**RE: Presbyterian Hospital Site Improvements
100 Central SE
Grading and Drainage Plan
Engineer's Stamp Date: 7/31/19
Hydrology File: K15D005**

Based on the submittal received on 8/7/19, the Grading and Drainage Plan cannot be approved until the following corrections are made:

EXISTING
DRAINAGE
MANAGEMENT
PLAN

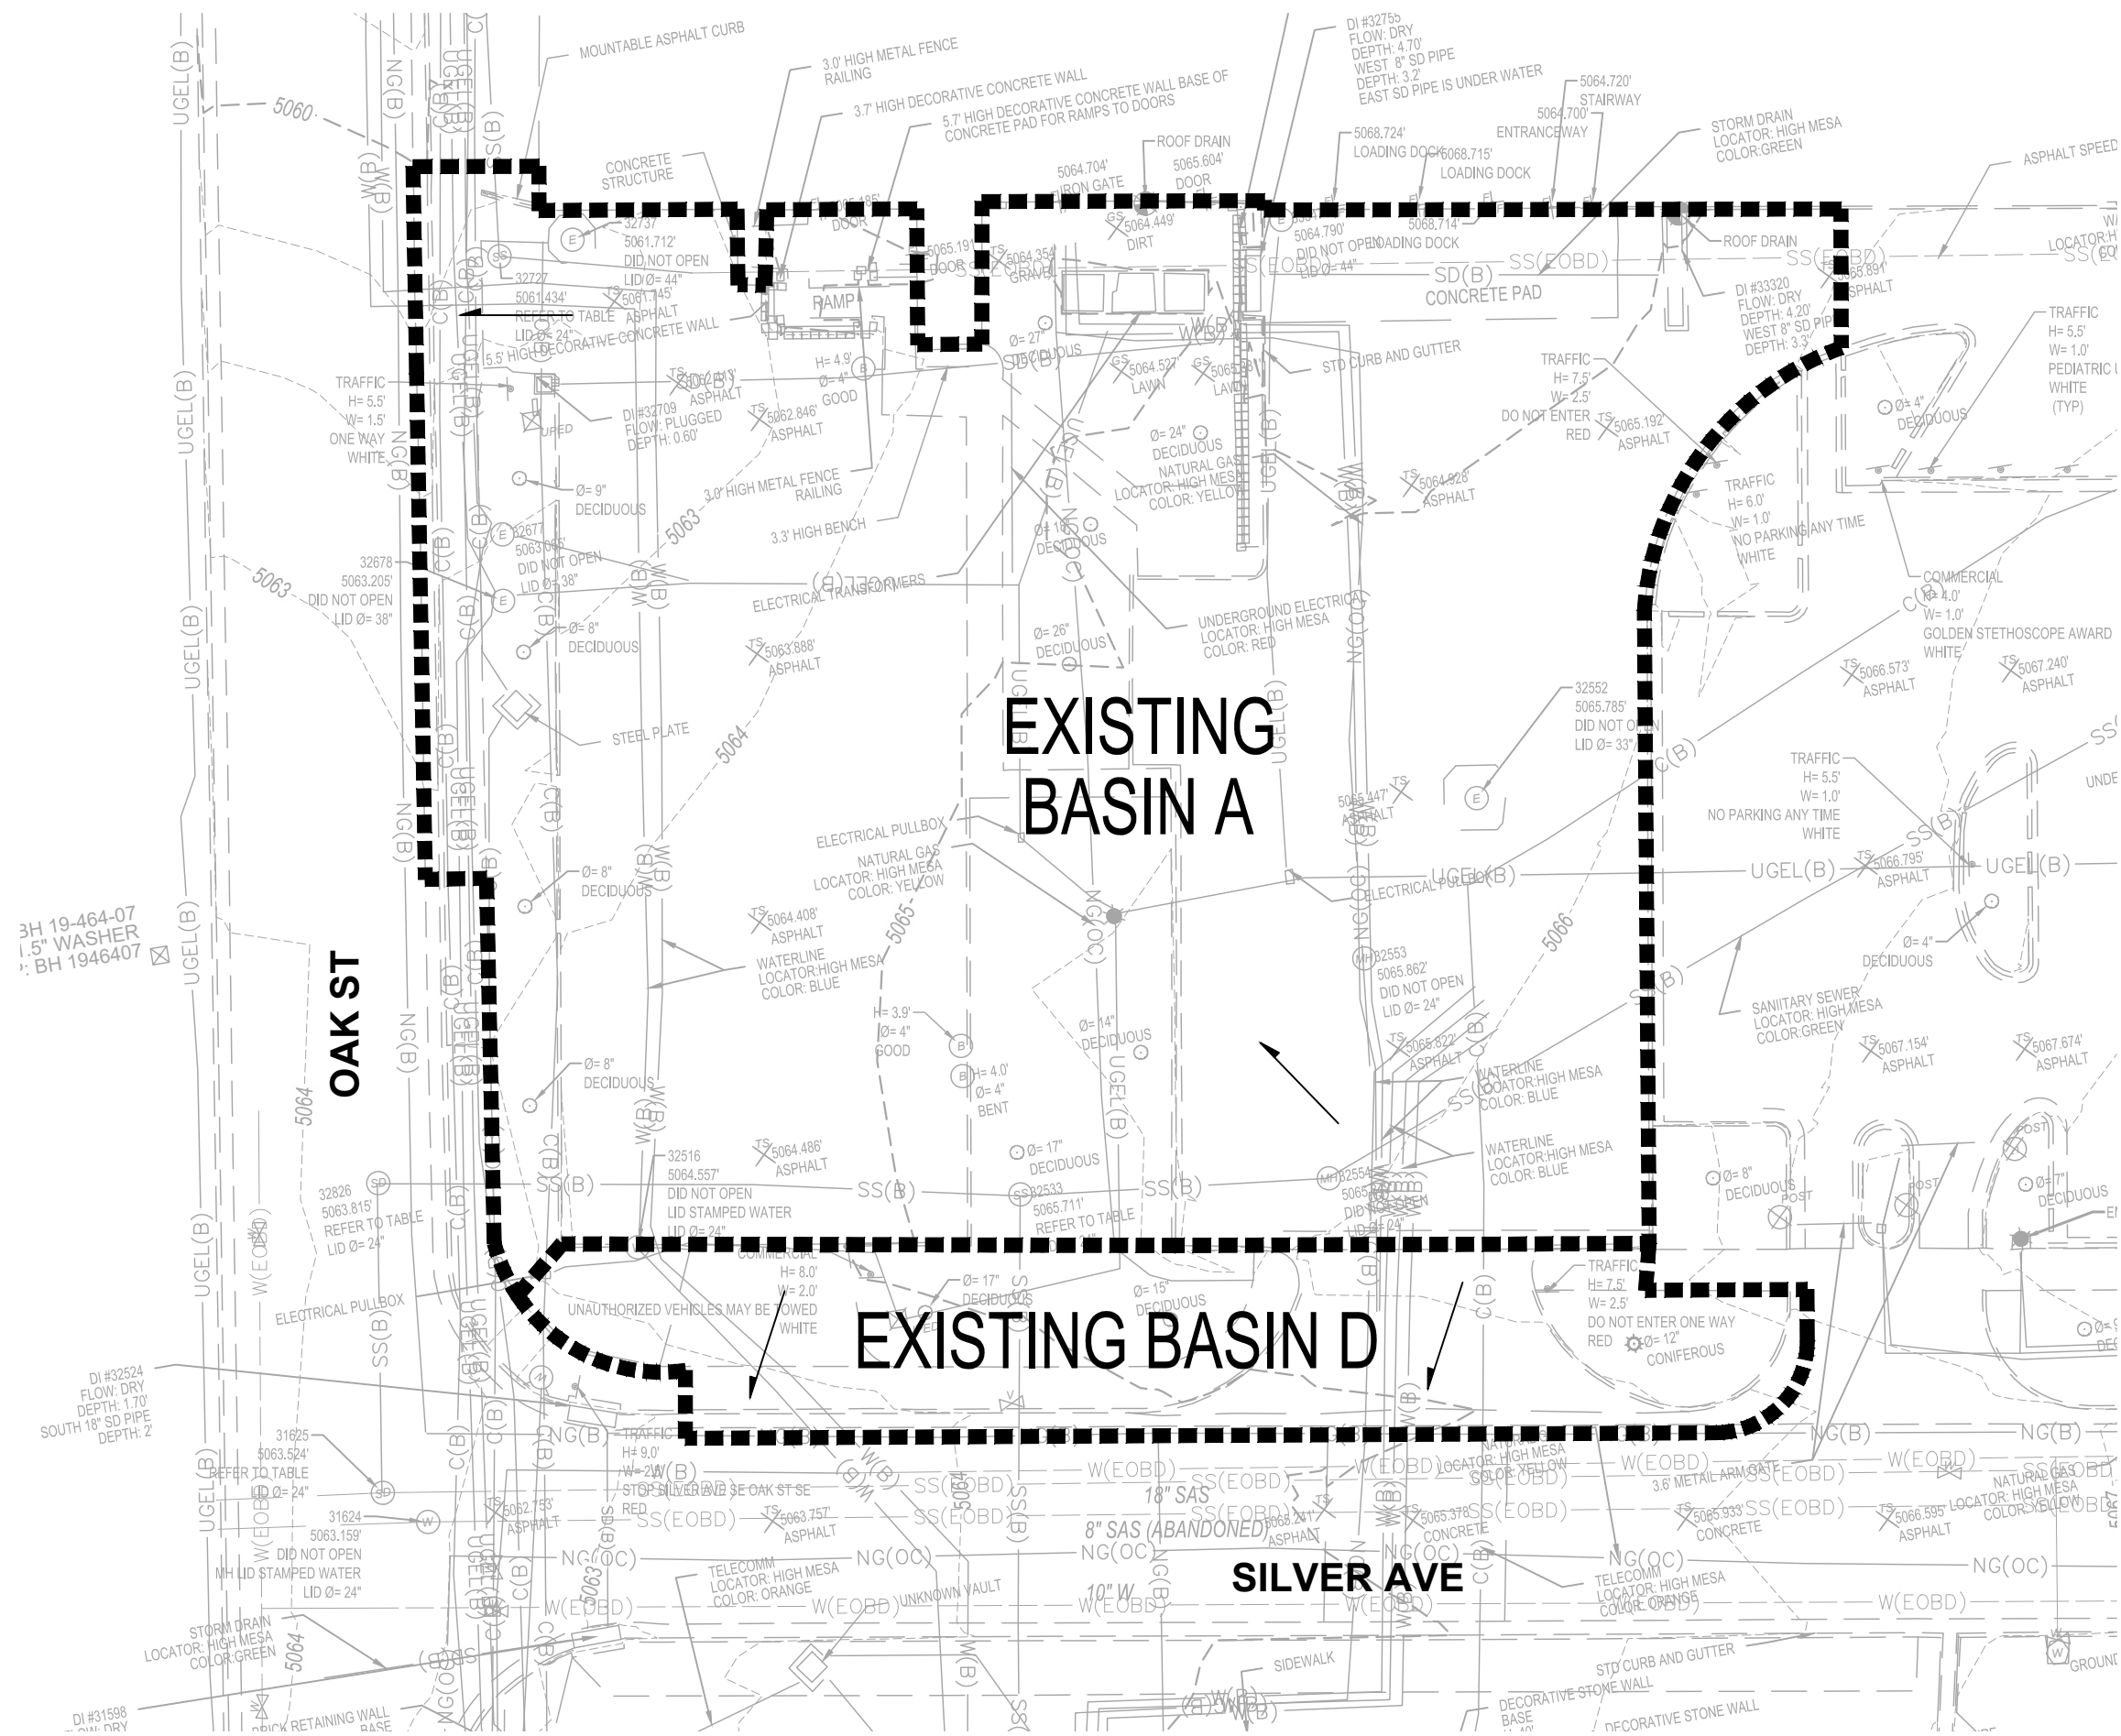
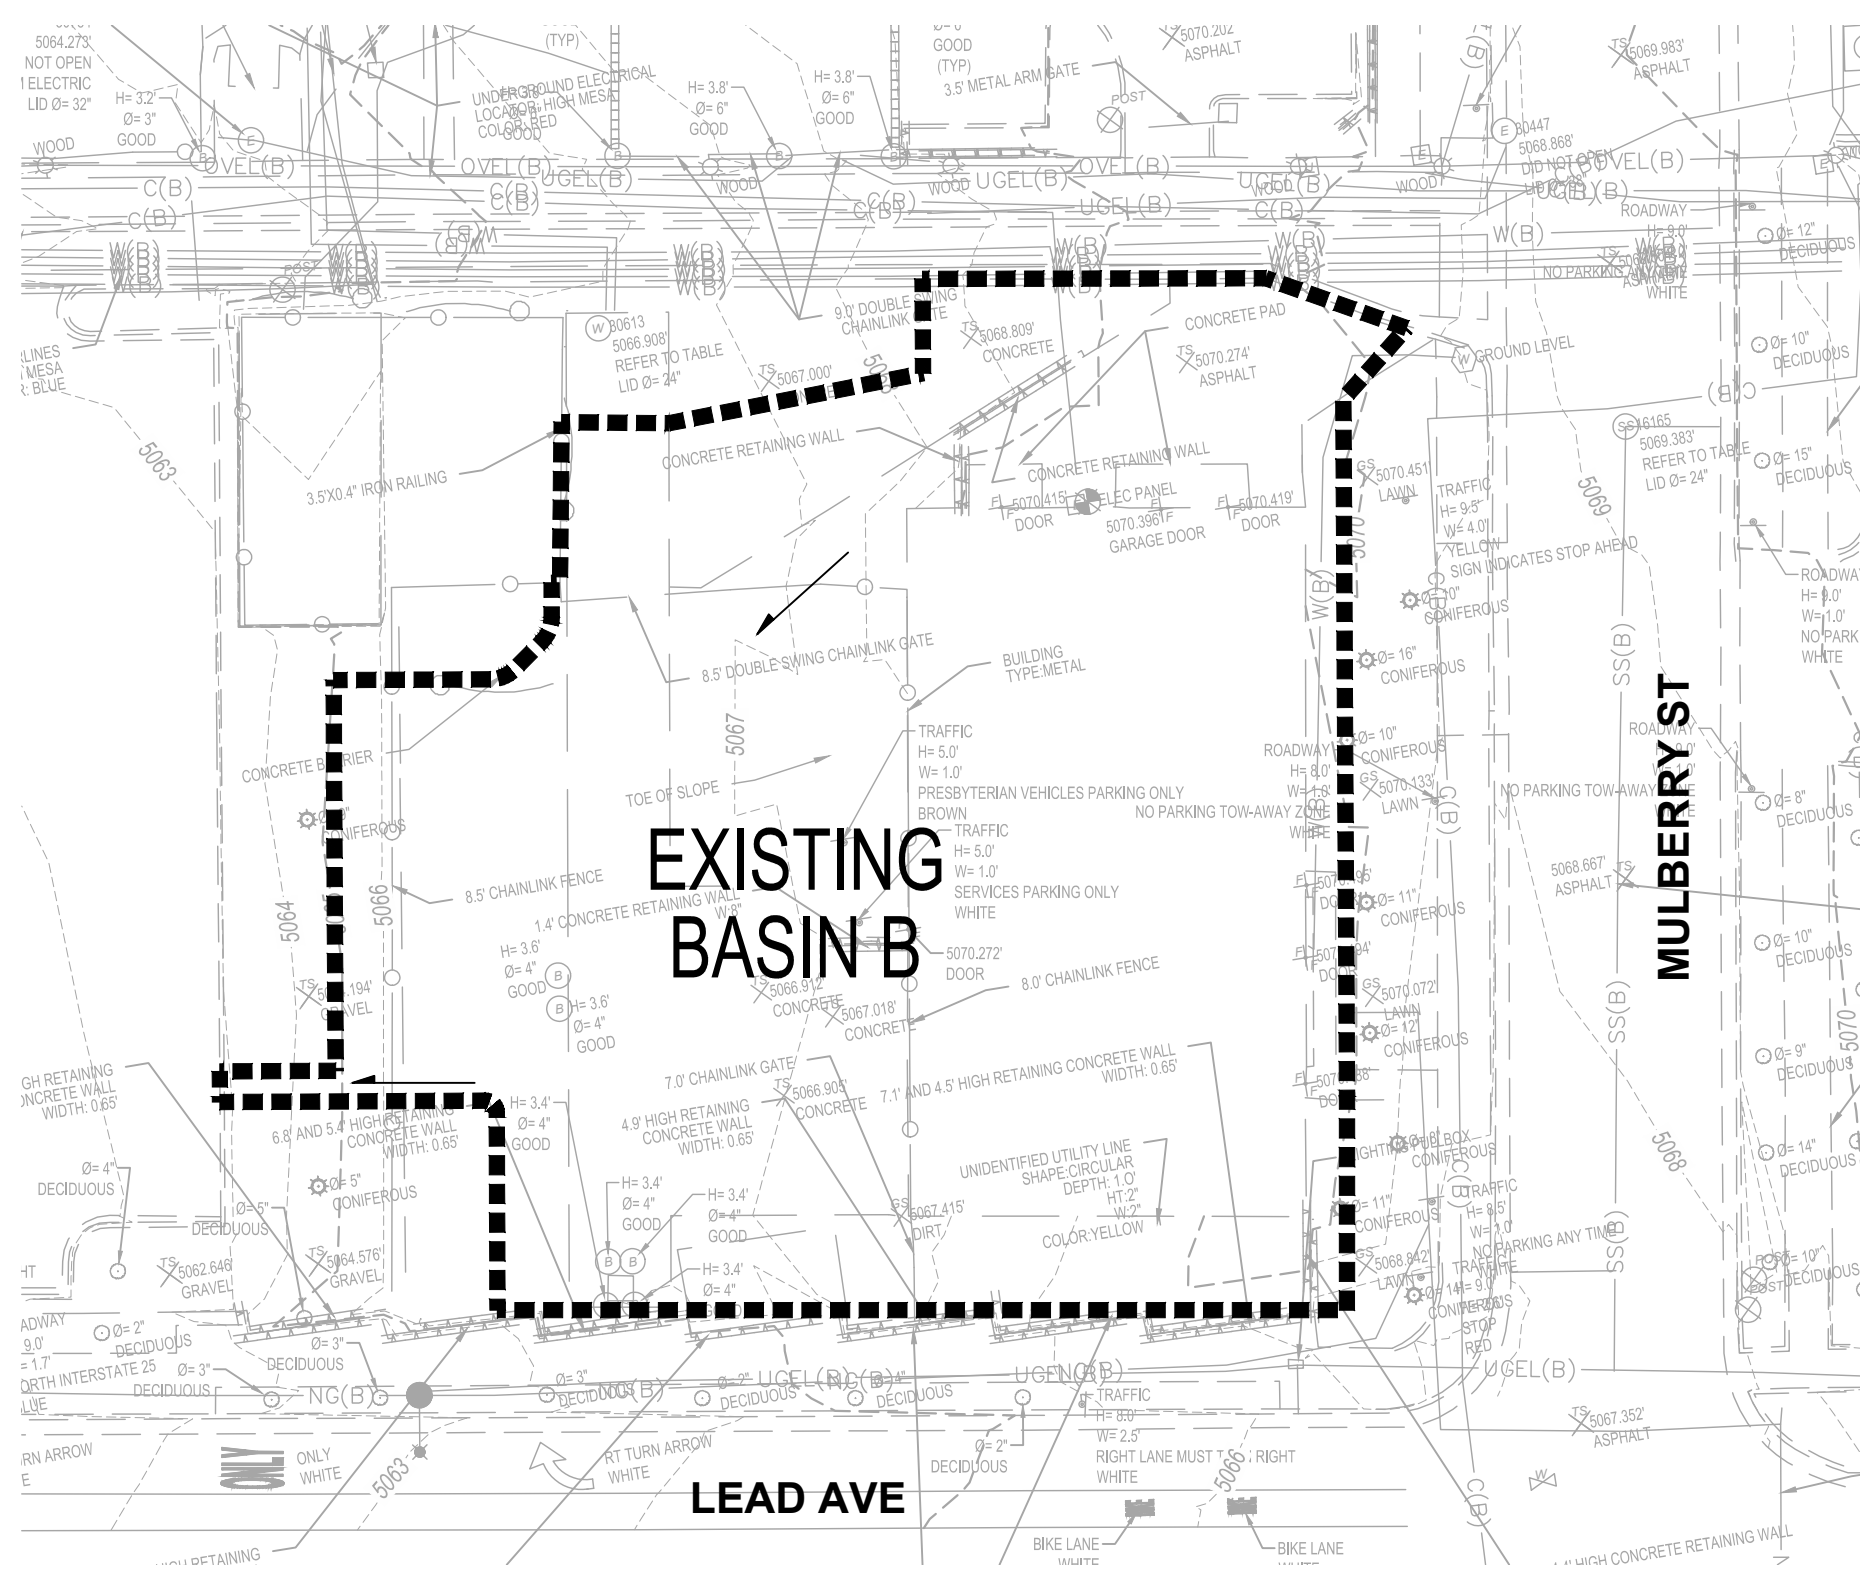
2. Provide project phasing as needed and assign this portion an appropriate phase number/name.
3. Each portion of the project (viewport) needs to include the street names.

4. Screenback or turn-off the extraneous survey layers.
5. Please use the most recent [standard SO-19](#) notes on the grading plan and callout the work to be performed by SO-19 Permit. If a Work Order is required than the SO-19 work will have to be performed by Work Order, not SO-19.

6. Provide management onsite for the Stormwater Quality Volume (SWQV) in accordance with the new drainage ordinance, § 14-5-2-6 (H) enacted 10/2/18 (Council Bill C/S O-18-2). You may elect to make Payment-in-Lieu of onsite management for the volume not captured. In order to pursue this, the plan must state that: you could provide onsite management, you do not want to (due to cost or convenience), and you are electing to make the Payment in Lieu of onsite management.

7. This site qualifies as redevelopment and is only required to retain runoff from the 80th percentile storm (Vol. = 0.26''*Imp.Area).

8. Include project benchmark and datum; all existing survey, proposed grades, and benchmarks must be provided in NAVD 88.
9. Payment in Lieu (Amount = TBD) of onsite management of the SWQV must be made.
10. Hydraulic calculations per the DPM Ch.22.3 are required for all sidewalk culverts, swales, storm drain, etc...
11. As a reminder, if the project total area of disturbance (including the staging area and any work within the adjacent Right-of-Way) is 1 acre or more, then an Erosion and Sediment Control (ESC) Plan and Owner's certified Notice of Intent (NOI) is required to be submitted to the Stormwater Quality Engineer (Doug Hughes, PE, dhughes@cabq.gov, 924-3420) 14 days prior to any earth disturbance.
